2025/0391

23 Windhill View, Grimethorpe, Barnsley

Erection of a two storey side extension following partial demolition of the existing detached garage (part of the side wall retained to form boundary treatment)

Drawing Title **PROPOSED ELEVATIONS**

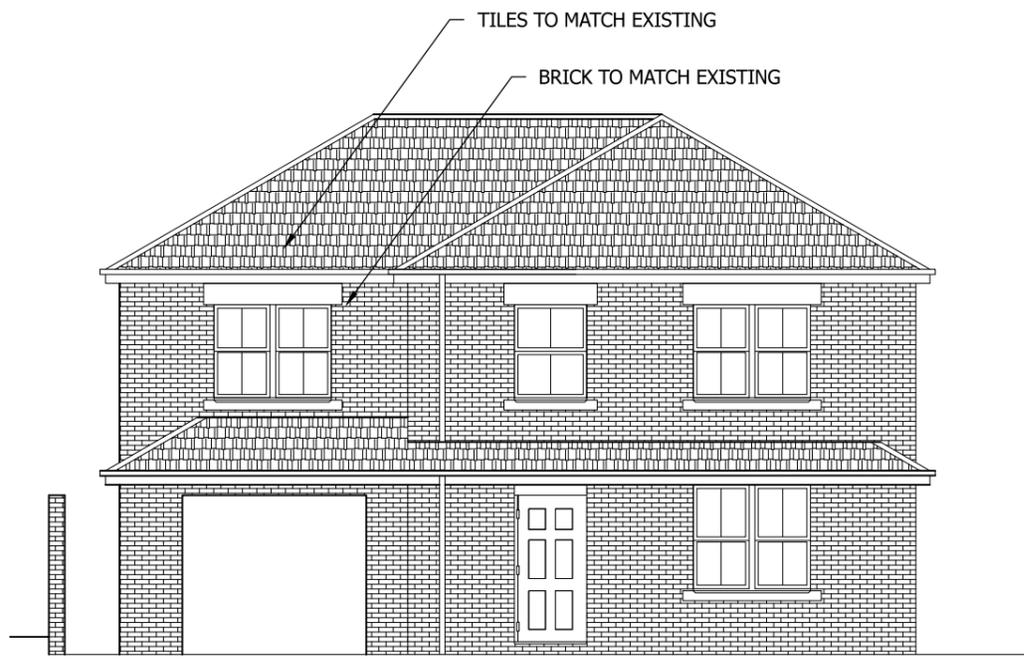
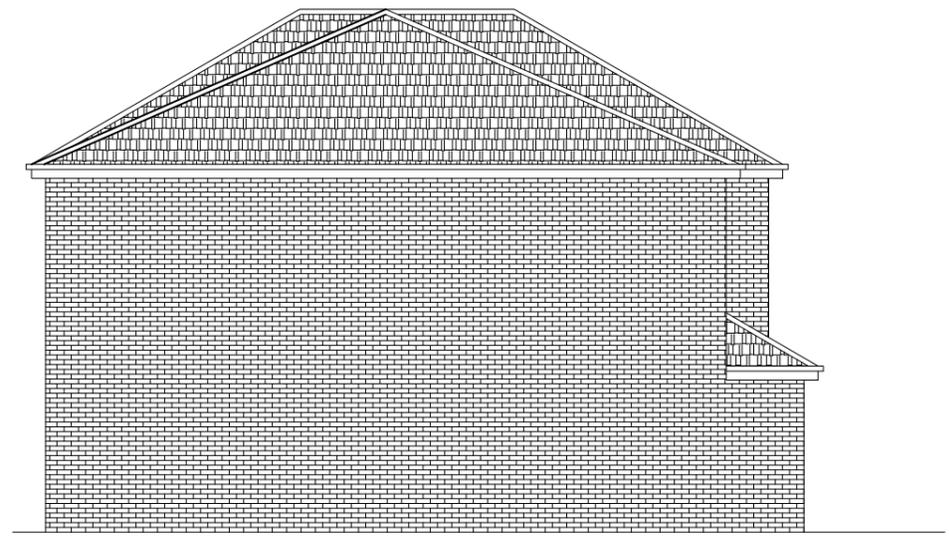
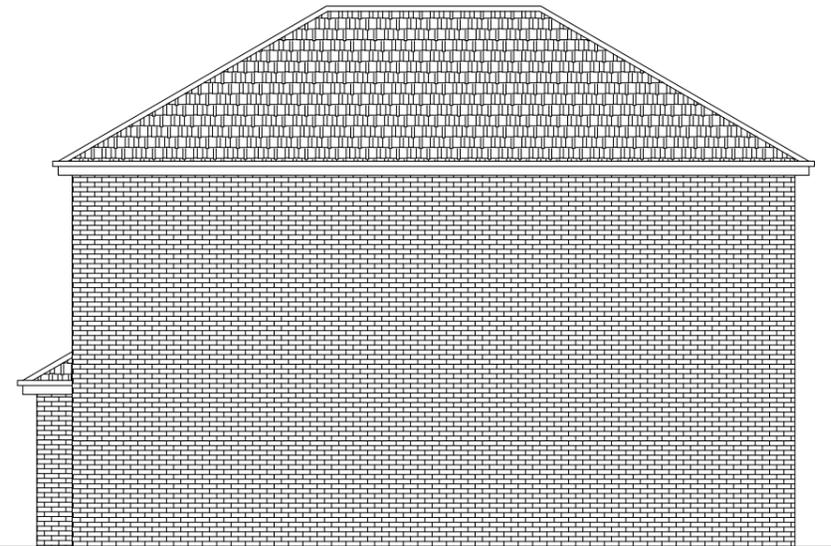
There will be no significantly harmful impact to visual amenity or character of the area. The proposal complies with the SPD which requires two storey extensions to be set back from the front wall and set down from the ridge. The proposal has also been amended to reduce its width and ensure there is a metre gap retained down the side of the property for rear access.

Drawing Title **PROPOSED PLANS**

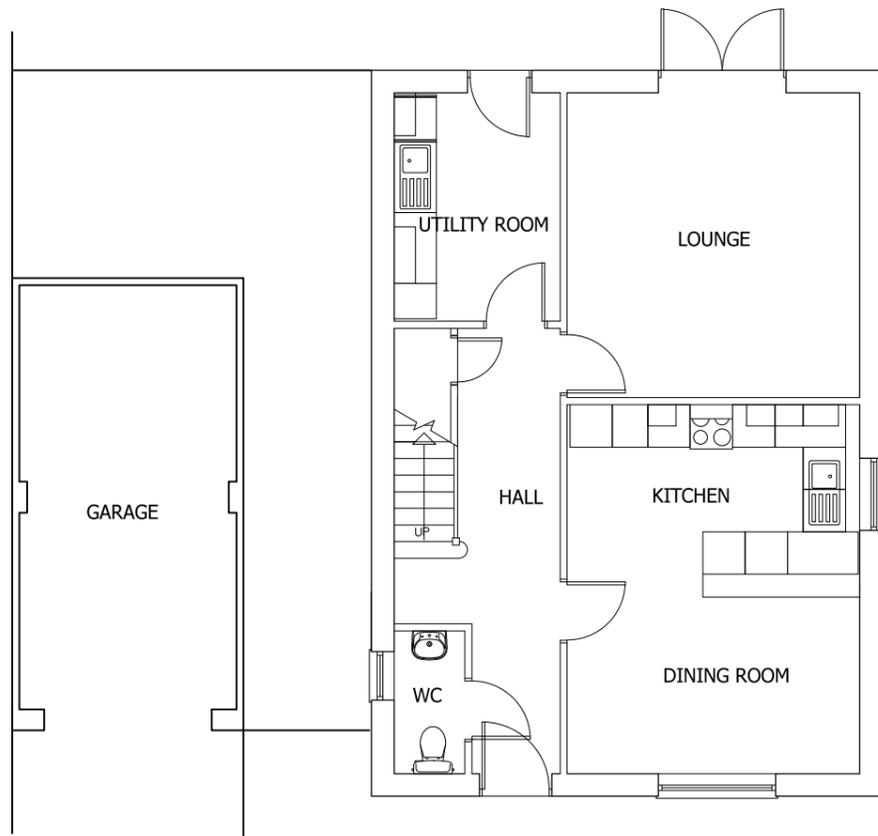
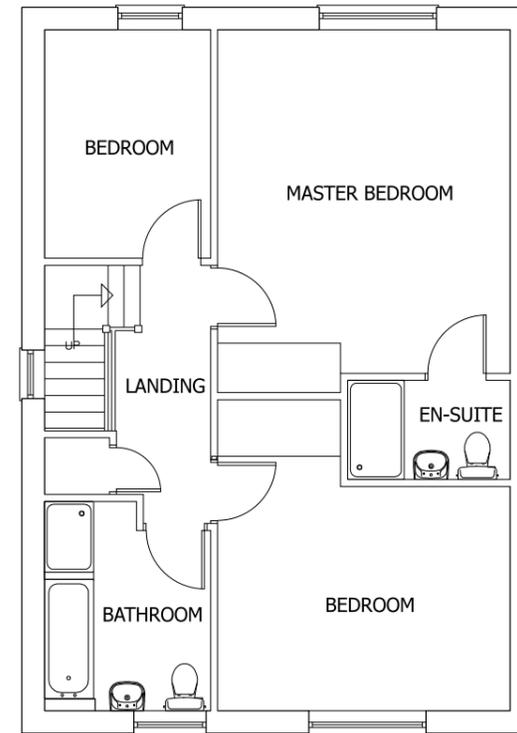
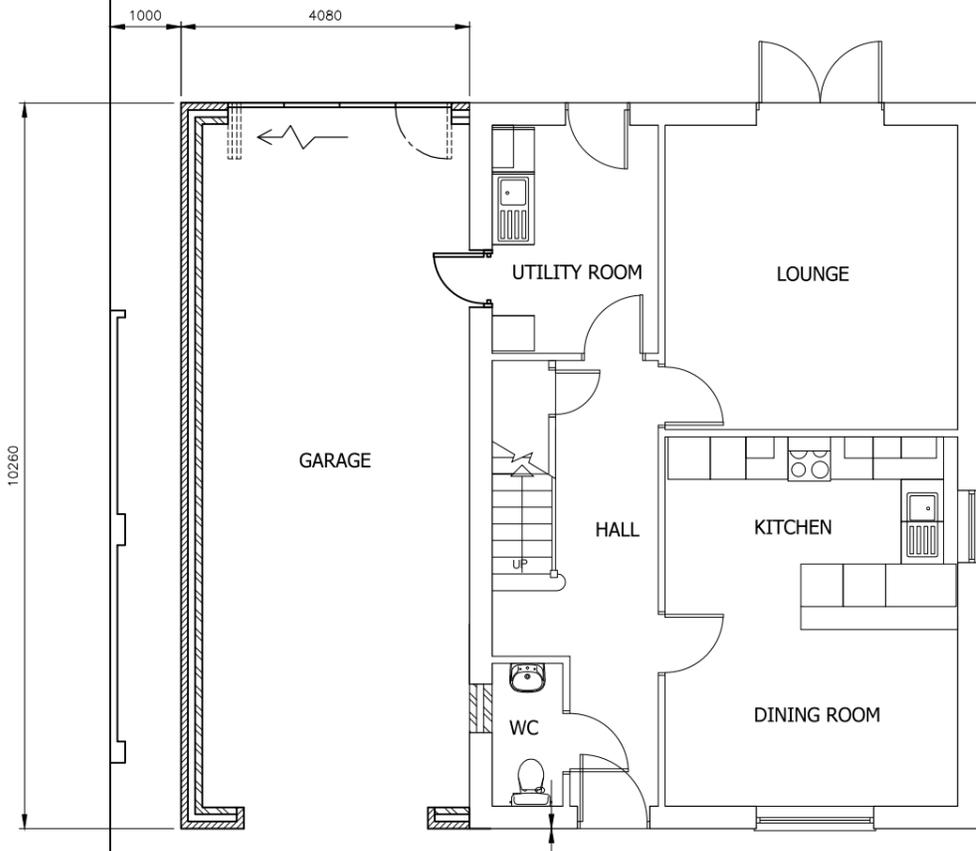
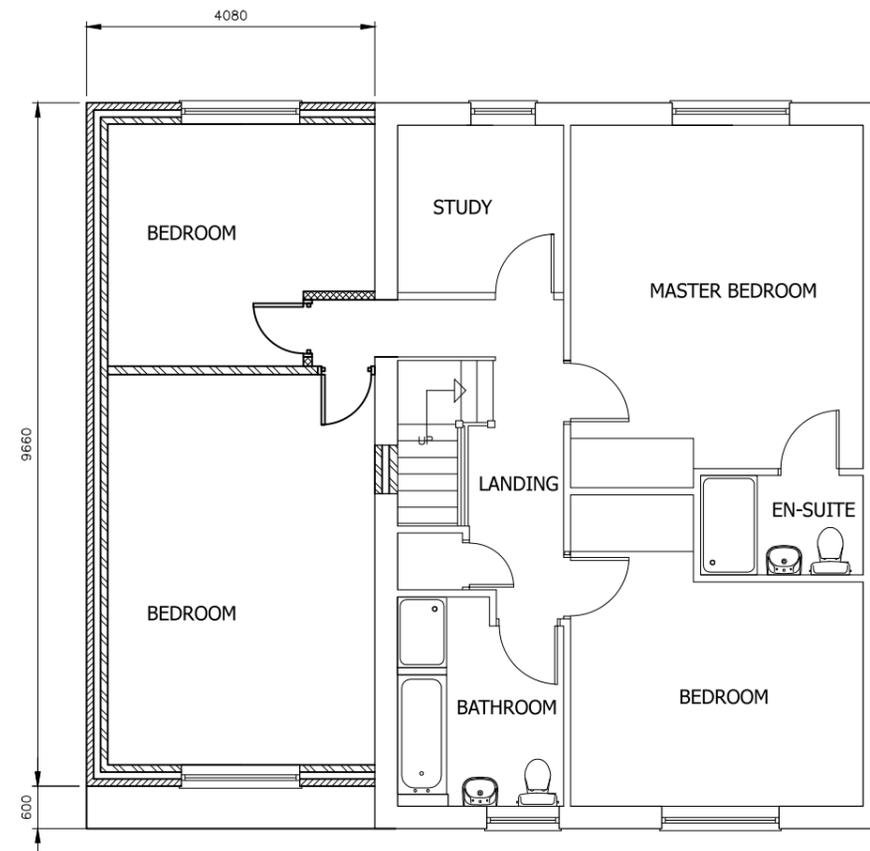
Firstly, in relation to construction phase impacts, the grading of land and proximity to No 21, these concerns have been overcome through the amended plans. A gap of 1m has been provided between the shared boundary and proposed extension. This should leave sufficient working room within the applicants curtilage to limit any impact on No 21. The current west wall of the garage will be retained to 2m height ensure there is a boundary treatment between the two properties and there will be no encroachment to No 21.
